EMBREY BUILDERS, LLC.

RFI

RFI #: 61
Date: 2/22/2012
Job: EB-02 Keller Springs Lofts
Phone: 877-777-5115

Subject: Fire Extinguisher Cabinets Locations

DATE	08-05-2011	SHEET NUMBER	3.1
PROJECT	11129

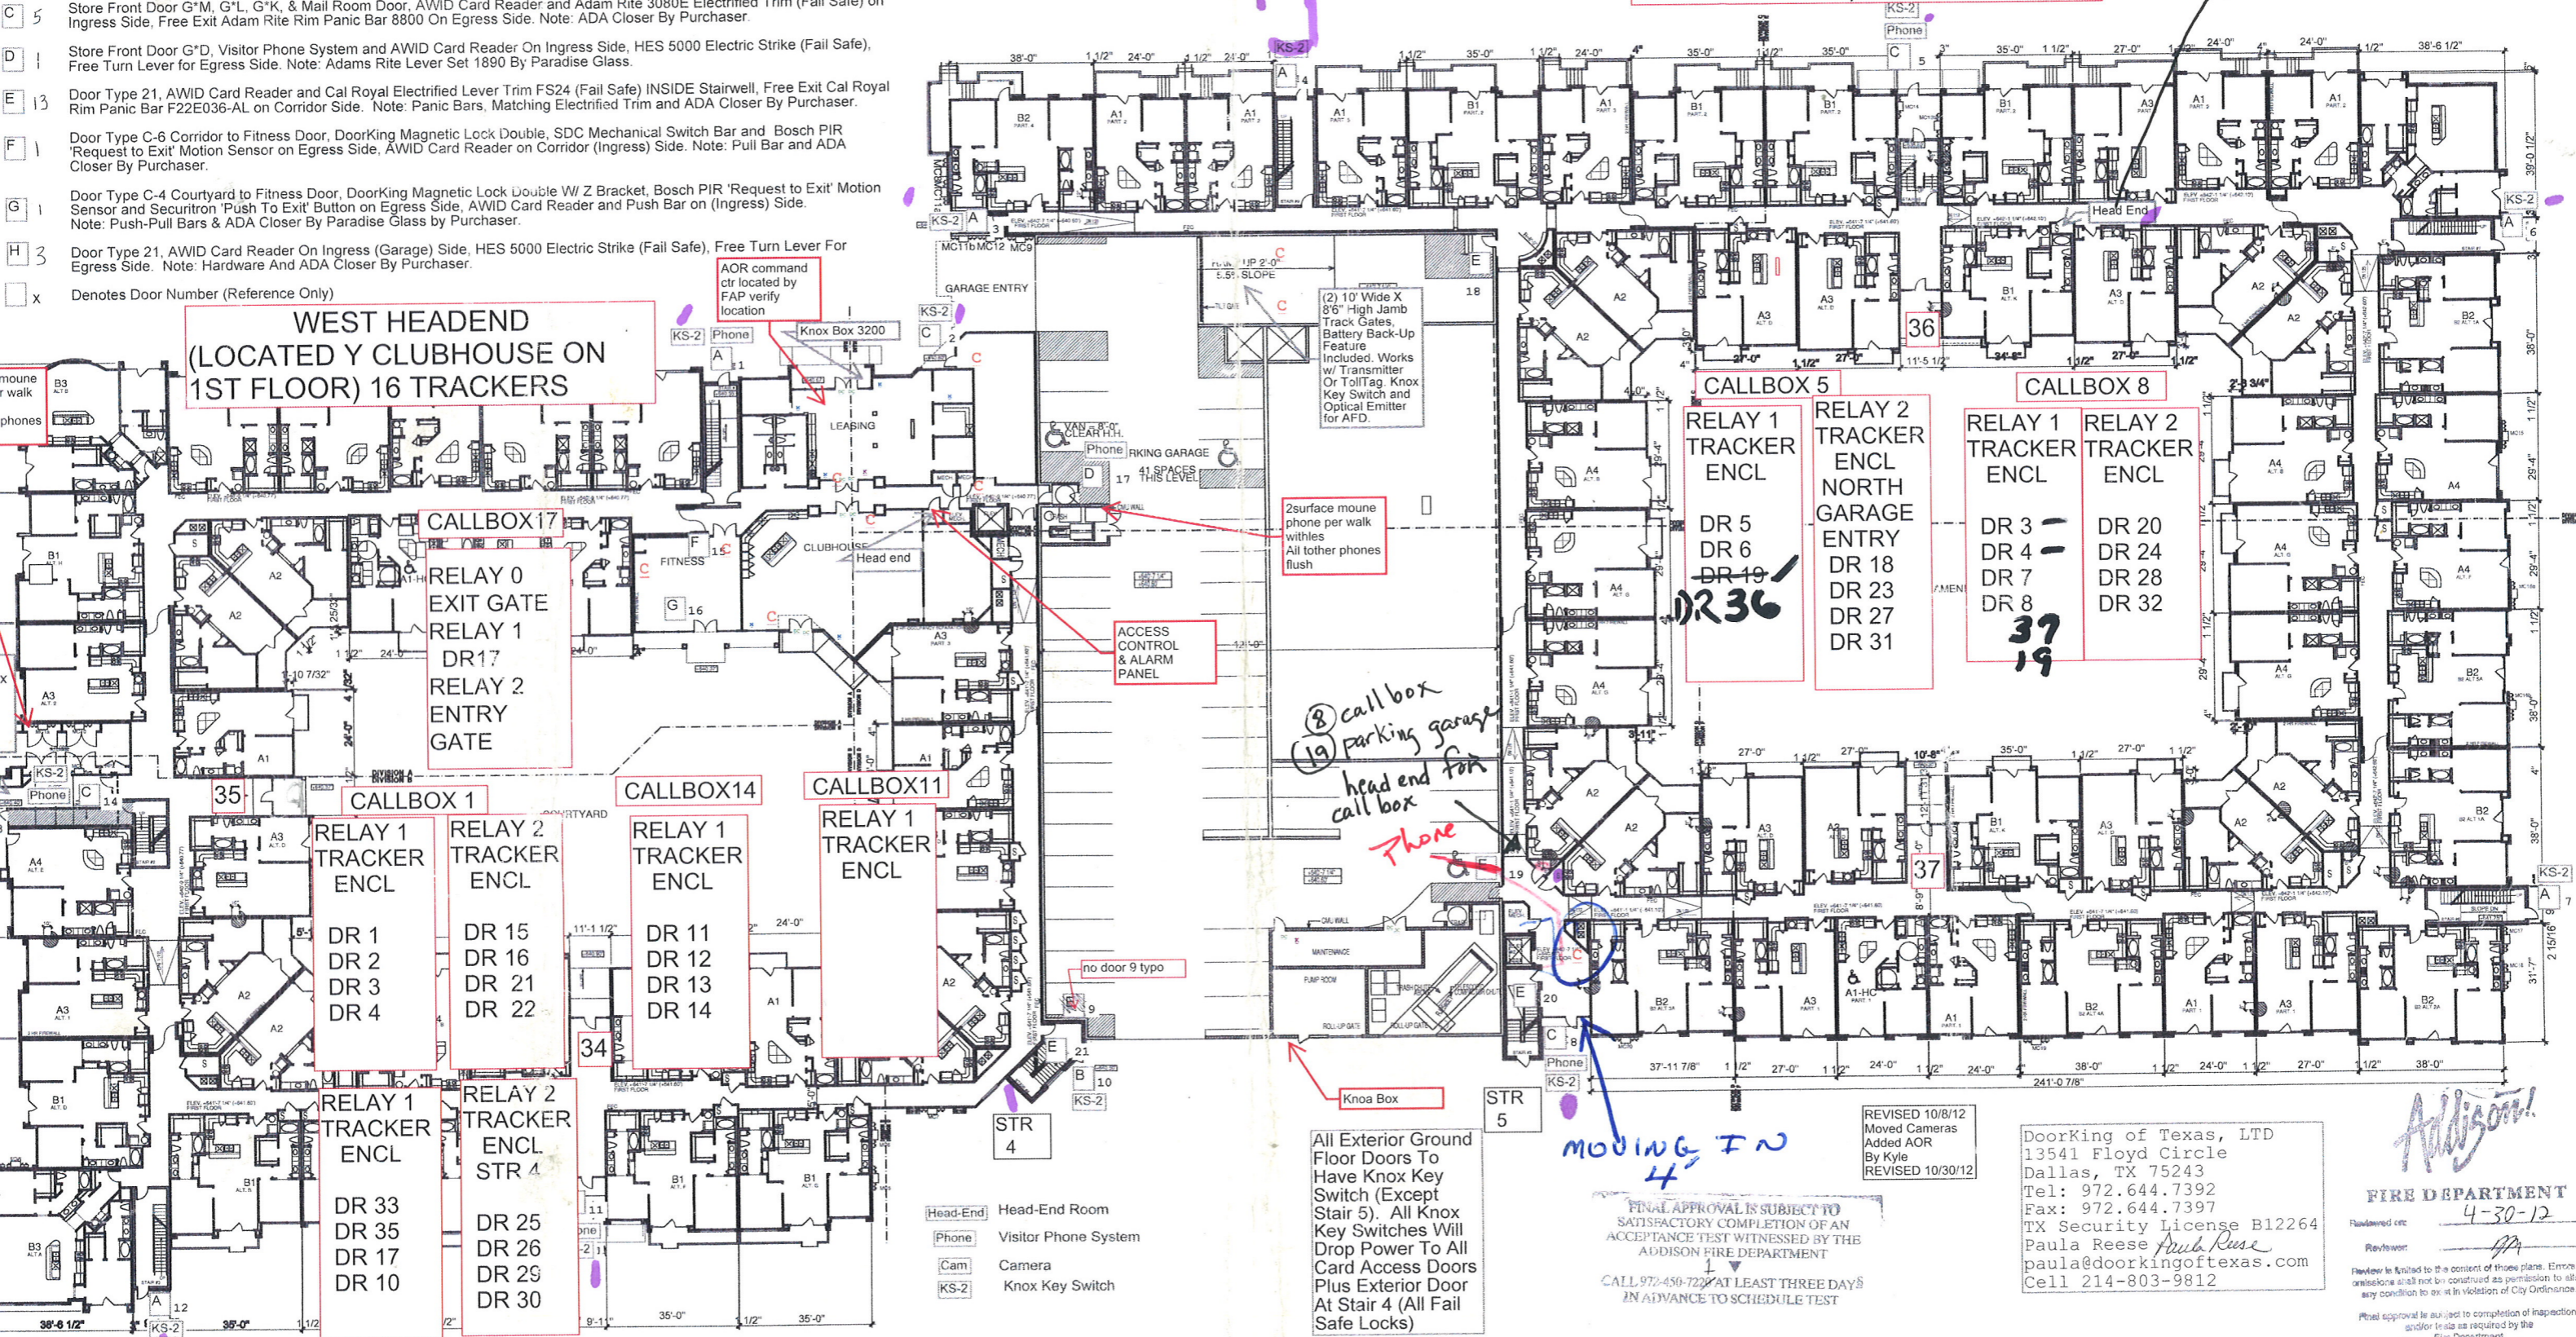
- There are some inconsistency's with plans for FEC locations in corridors.
3.1A shows 2 FEC
3.2A shows 1 FEC
3.3A shows 1 FEC
3.4A shows 2 FEC
Do you want 2nd FEC added for 2nd & 3rd floors?
- On sheet 3.4F - FEC mark is missing on A4 All G wall.
The FEC is shown on 1st, 2nd and 3rd floors, does the FEC need to be included at 4th floor?
Please verify all sections for coordination and consistency.
- Do we need fire extinguishers in club/leasing? We have assumed 1 for club and 1 for leasing.
- Do we need FE in parking garage and if so what type of mounting?

We need the measurement which is missing on sheet 3.1A. Attachment shows location on dimension needed.
Note: need to know if the dimension given will be from face of precast wall or the backside of corridor wall. There is a 2" difference between the two.

The cut shown on A3.1A points to Detail 2/A7.2. That detail is not there. Please provide it. Also, it appears that the separation wall stops at the corner of the A3 unit at the patio. Please provide a cut showing what type of wall is between the club and the patio.

In the Clubhouse area at the mechanical shaft, it shows 1/A7.2 but that detail is not there. Please provide a detail if needed. Are we to use the 20/A8.2 detail? With the different wall types shown on A3.1A, the sheetrock will not line up. Does the cross hatching mean that the wall extends into the storage room and the mechanical closet? Please provide cuts at the locations shown in red.

On sheet 3.1A at stair #1 we have a F.F. elevation 640.55 at the inside of entry door. It also shows a F.F. elevation 637.85 on the exterior side of the door to the stairwell. On Landscape 2C the same are shown F.F. elevation 640.55 for both sides of the door to stair #1. Please review and designate the correct elevations. We will need a revised sheet to add to our project plans.

Response:
1- Yes.
2- Yes. I've checked all locations and the one's you mentioned are the only problem locations. I adjusted 2 other FEC locations by moving them a foot or so now all FECs line up in the same spot from floor to floor (except for the Club and Garage areas).
3- I've placed the 2 FECs you mentioned in sheet 9.1
4- Yes, we need them in the parking garage. I've updated the sheets to reflect this. Double check with your local Fire Marshall, but I'm confident that a surface mounting will be fine.

Response:
see next pages for a graphic blowup of this area.

Response:
The sections requested are drawn.
Please see next pages of this PDF.

Response:
Sections have been drawn and wall hatching has been updated. With 3.1A and 7.2 updated, that should answer all these questions. The updated wall hatching should eliminate the need for the 2hr wall type to be shown in red, but if you need it, I'll draw it.

Response:
The 640.55 elevation is correct on our drawing. I talked to Ryan at BGO and he agreed. The door and sidewalk are flush.
